From: Michael Eastham
Sent: 21 March 2018 12:26
To: Planning.Responses
Subject: FW: 4485 - Courtwick Littlehampton - variation of conditions 4 & 24 - Ref LU/408/17/PL

Would you like "Drawing Number 4485/314 Rev. E – North Eastern Footpath Link Details Plan" to be listed as an additional plan in the varied Condition 4, which was imposed on the outline planning permission (LU/355/10/)?

Drawing Number				Rev.
4485/314				E

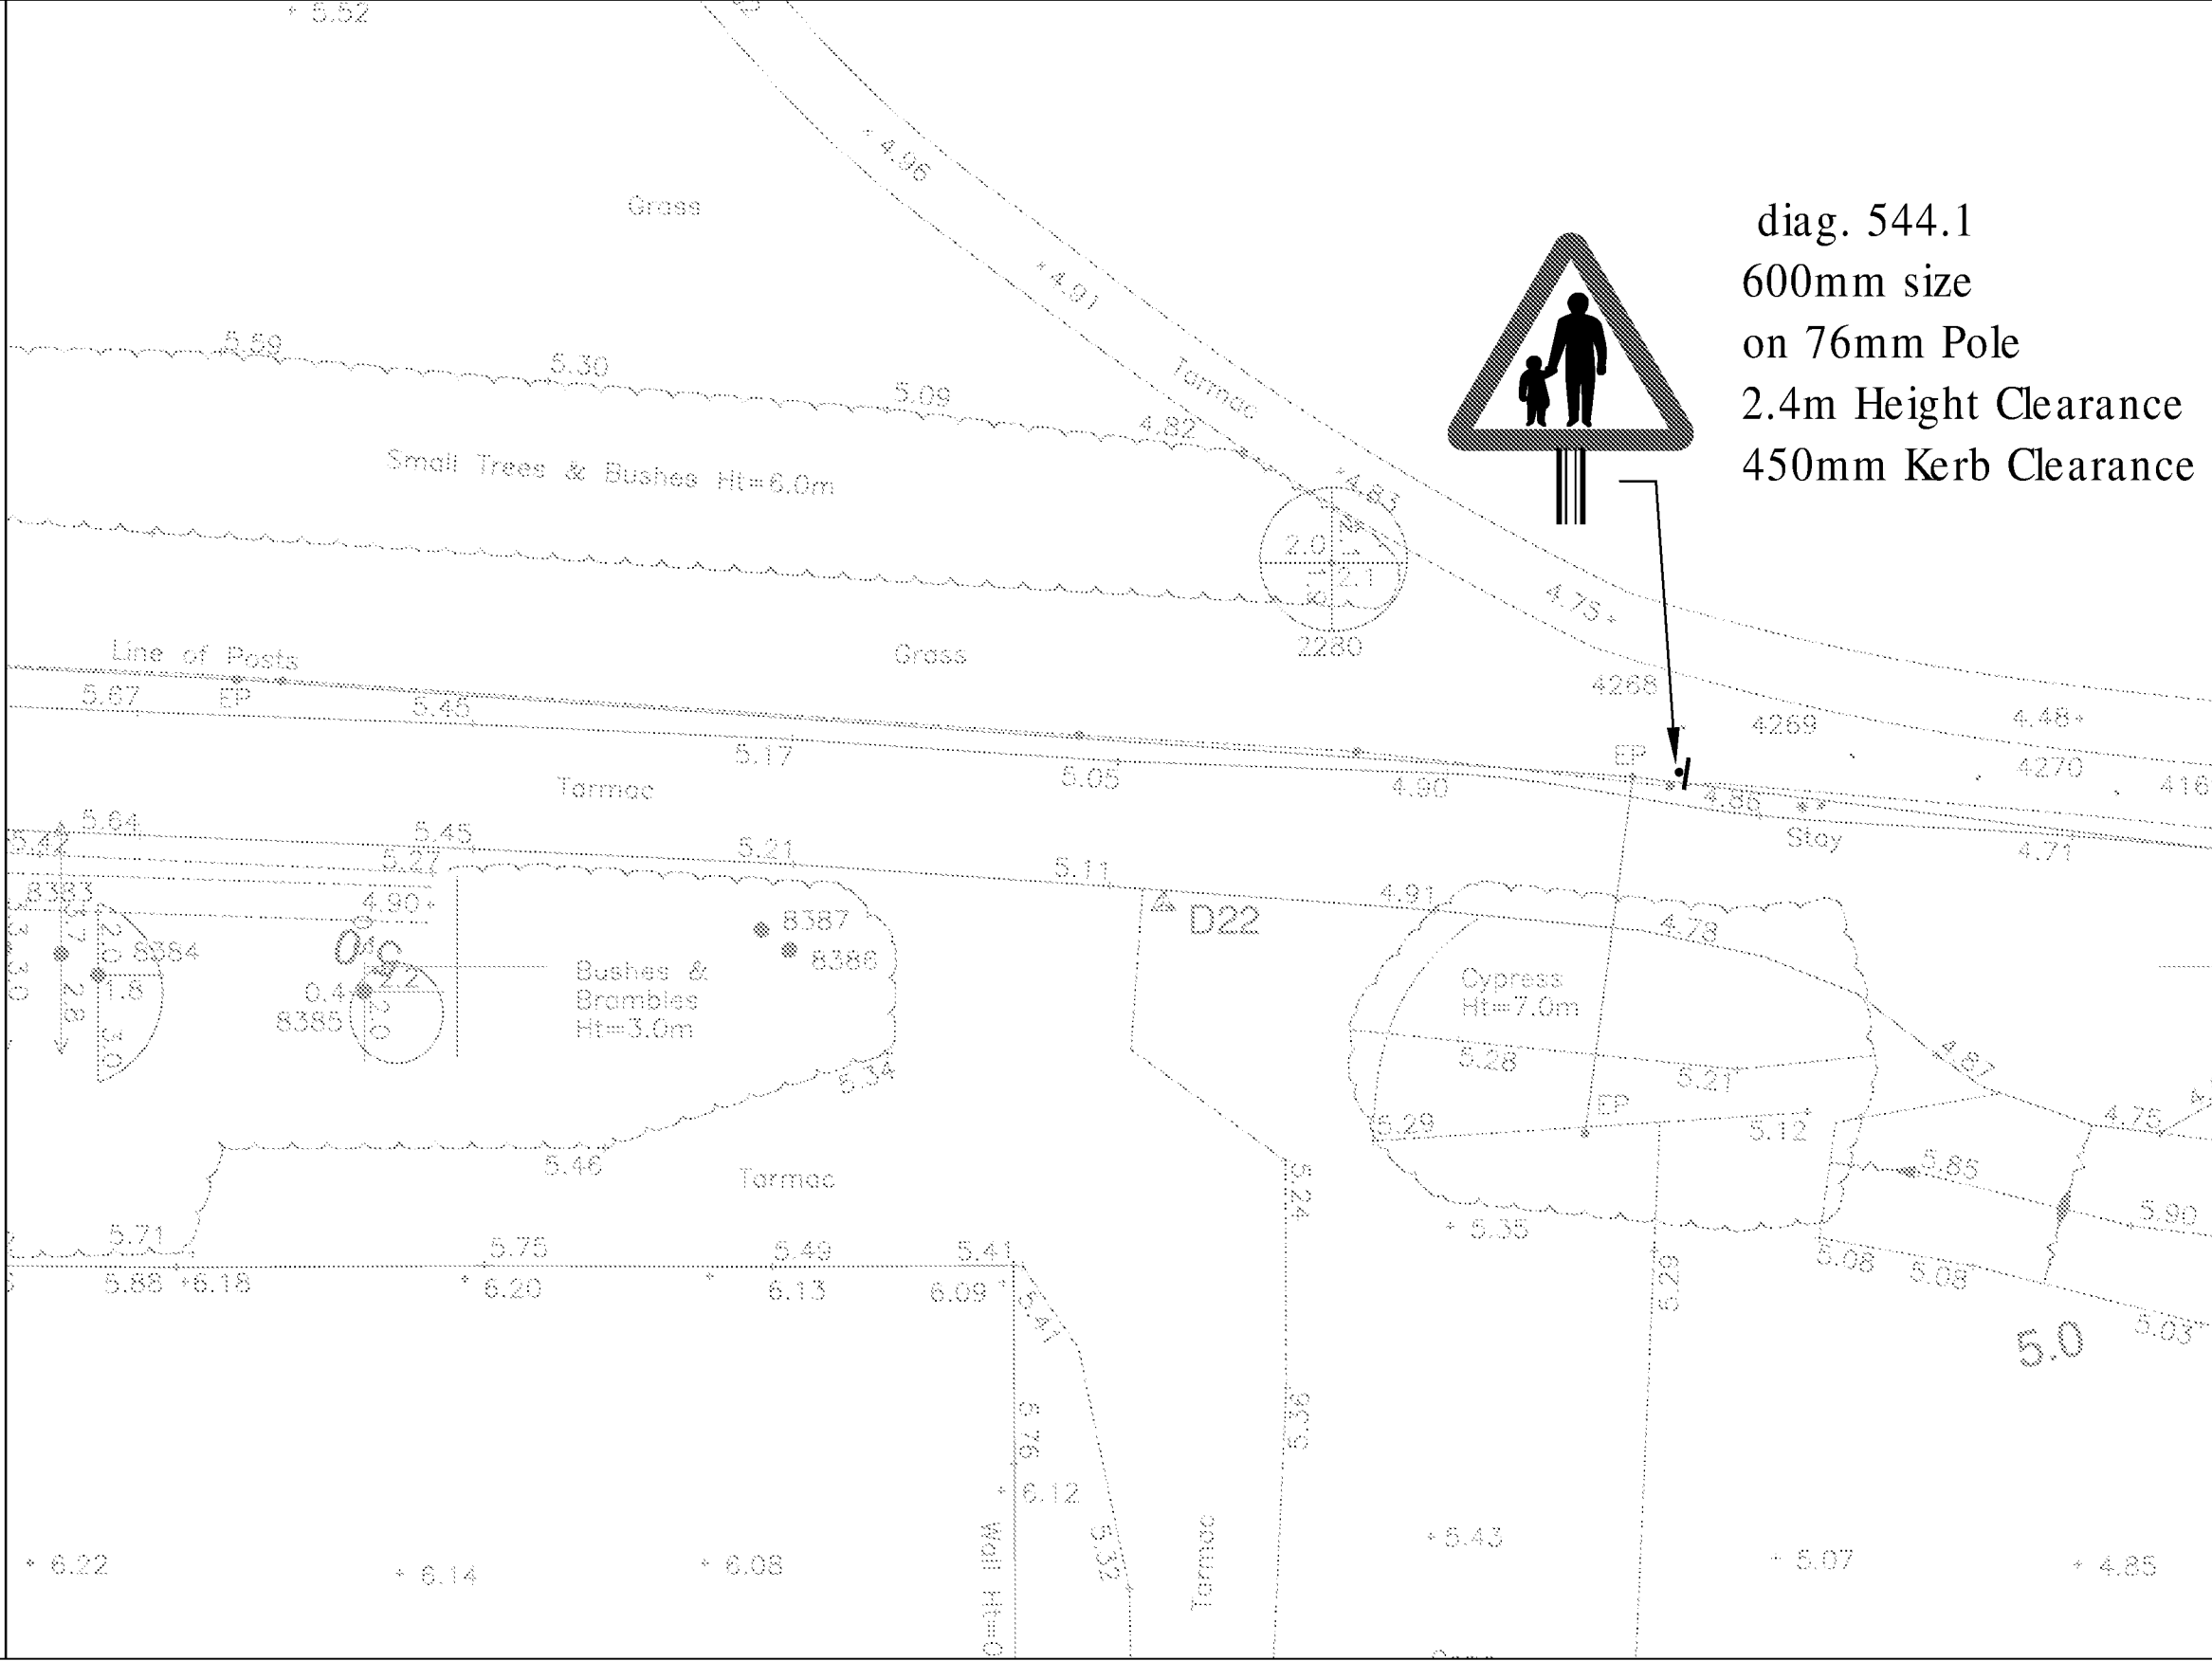
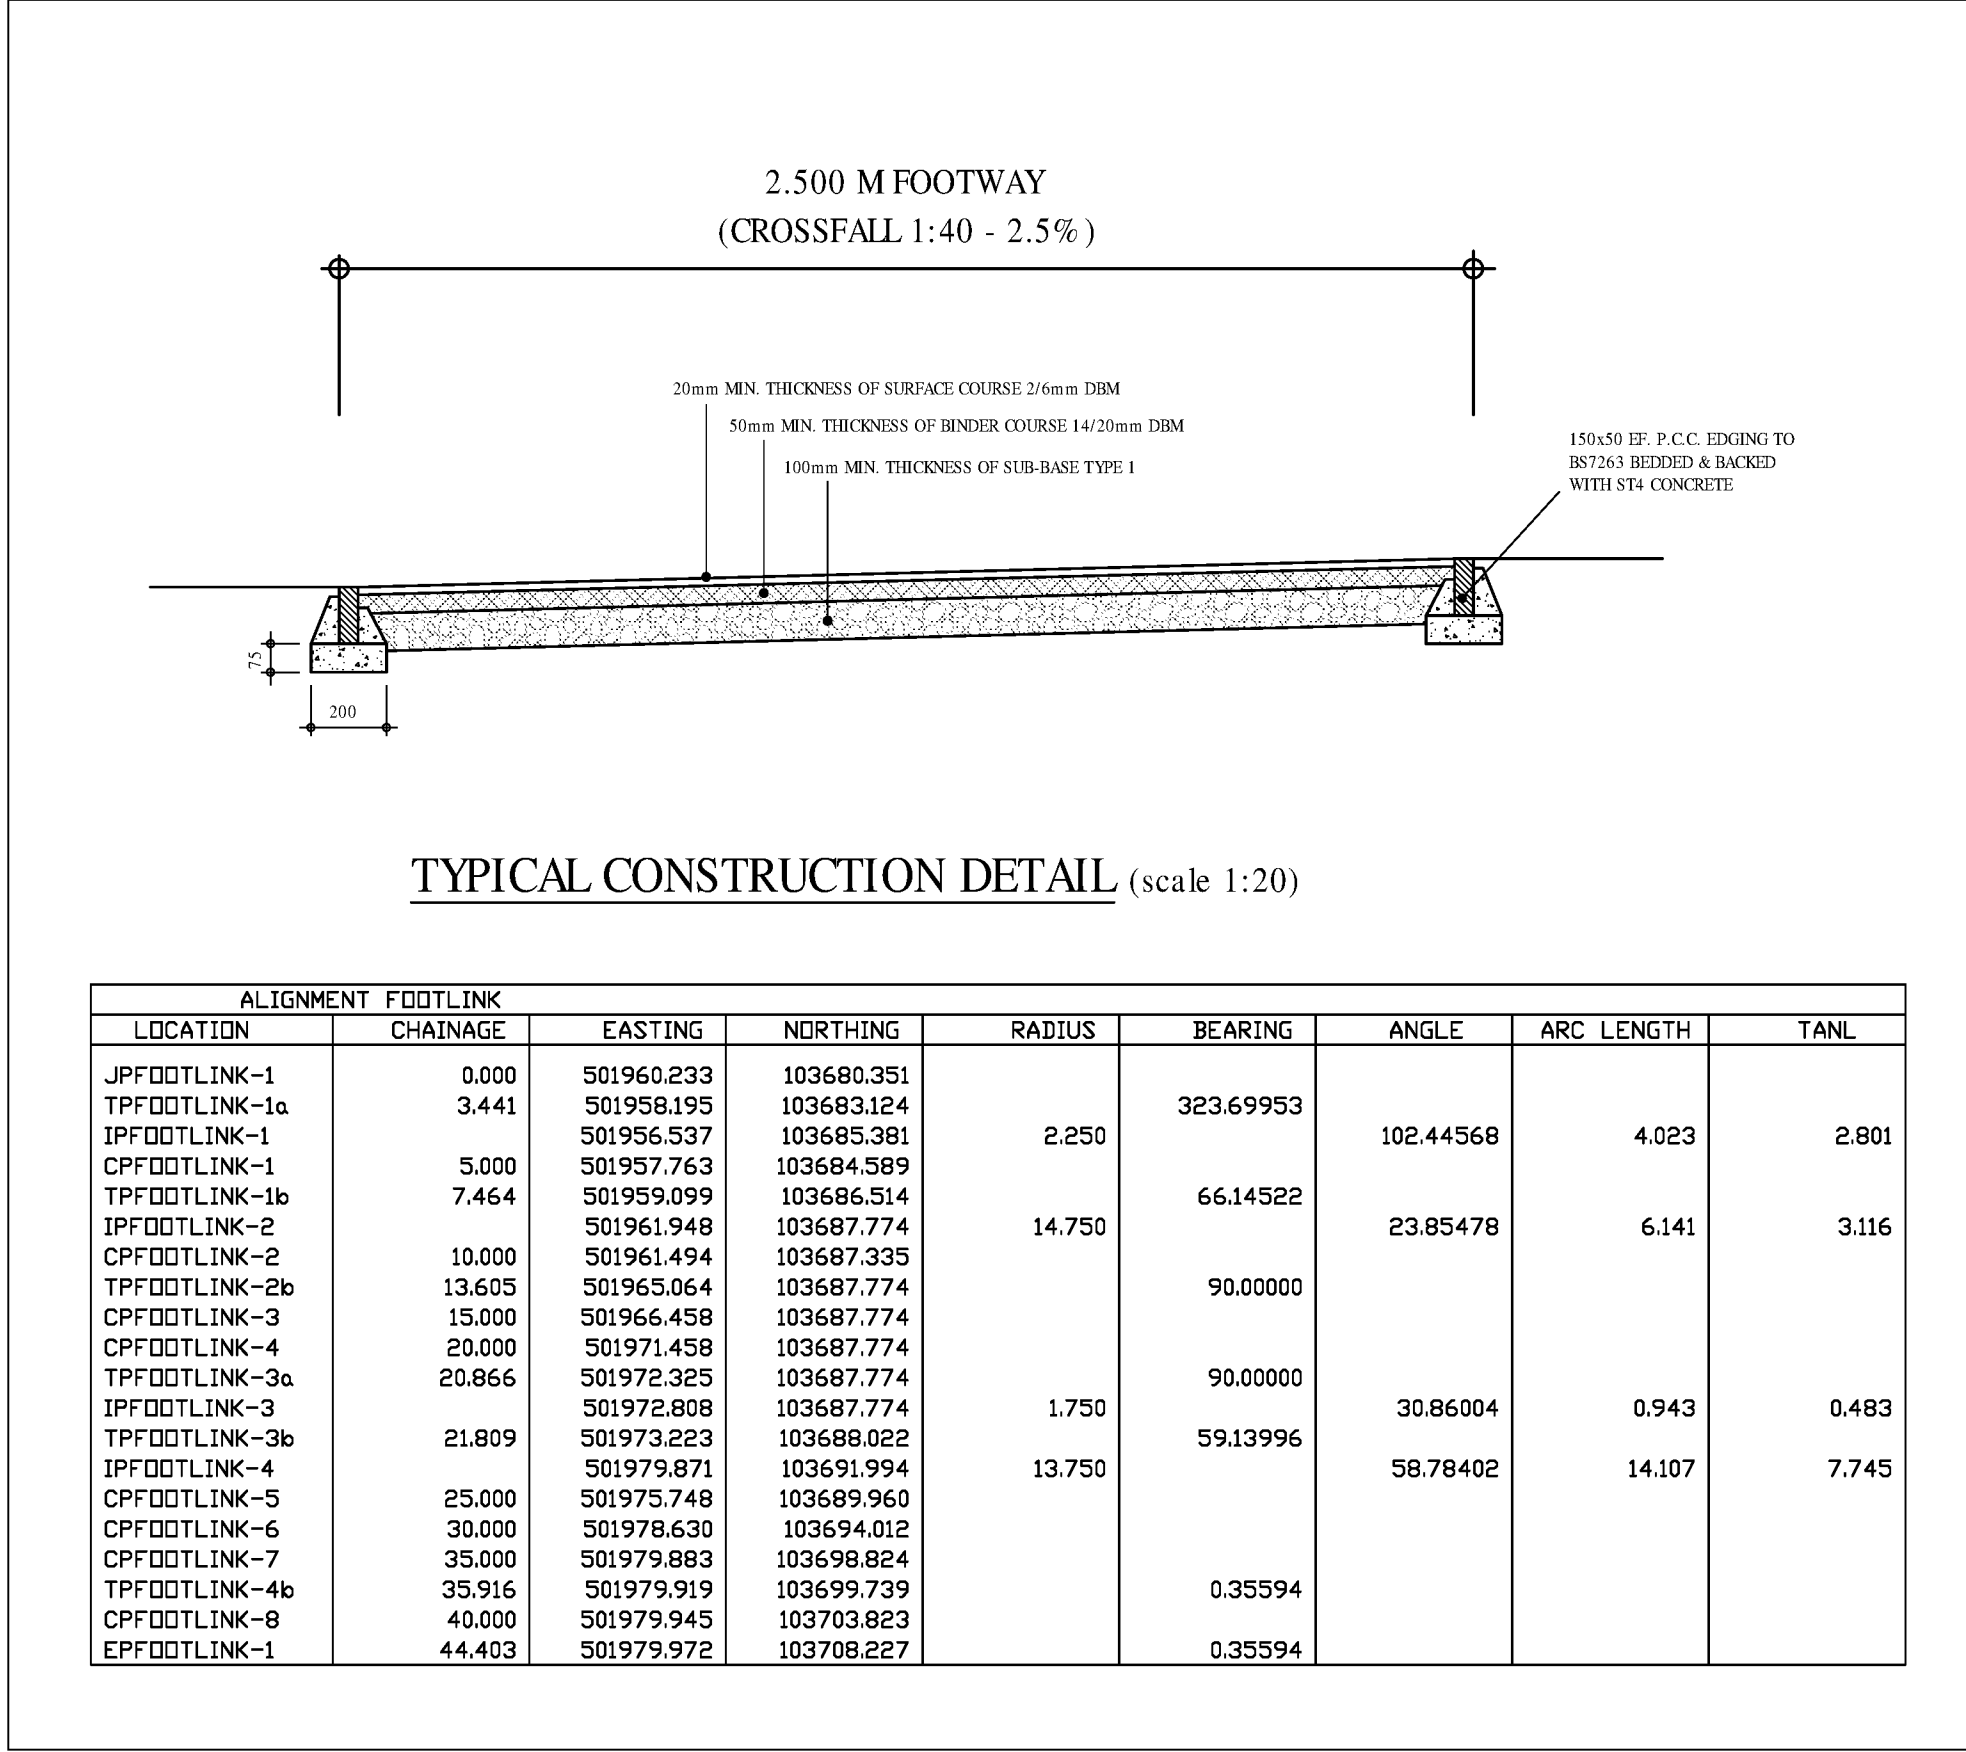
As far as I can see, the arrangements proposed by Bellway is still one that looks to be suited for cyclists. Furthermore, the stagger of the barriers might be the wrong-way-around and the use of hoops with 1200mm clearance underneath would permit a young child to walk or run underneath. They also might need to be a bit closer to the road (albeit not within the sight line splays). Finally, the gap in the middle would permit cyclists to traverse fairly quickly so should – I believe – be narrowed. However, the applicant would still have to demonstrate that those with pushchairs and mobility scooters can get through them. Sustrans guidance might assist here (*SEE LINK BELOW). Finally, there must be barriers (e.g. fence) either side to prevent the gates from being by-passed. In any event, appropriate design guidance will have to inform the final solution. However, it is still unclear what design guidance they have used to inform the proposal as the extract that you/they have provided is not one I have seen before. This should still be clarified, please.

For information, I have attached an example photo showing barriers that would prevent children getting underneath (although the spacing between the stagger still looks too large).

I don't think they are far-off now – we just need to see a bit more detail and confirmation of what guidance has informed what's shown.

Further to Tim's additional comments, please find attached the updated Footpath Layout with adjusted barriers and additional notes regarding supplemental planting (tba on site).

The 'Sustrans' guidance does not provide a specification for non-cyclist barriers and the former was taken from the 'paths for all' guidance with a recommended spacing of 3m – though from 'Sustrans', this is acceptable for cycle use. I have reduced the spacing to 1.5m and have also provided a tracking diagram for a mobility scooter which confirms that this spacing should be acceptable.
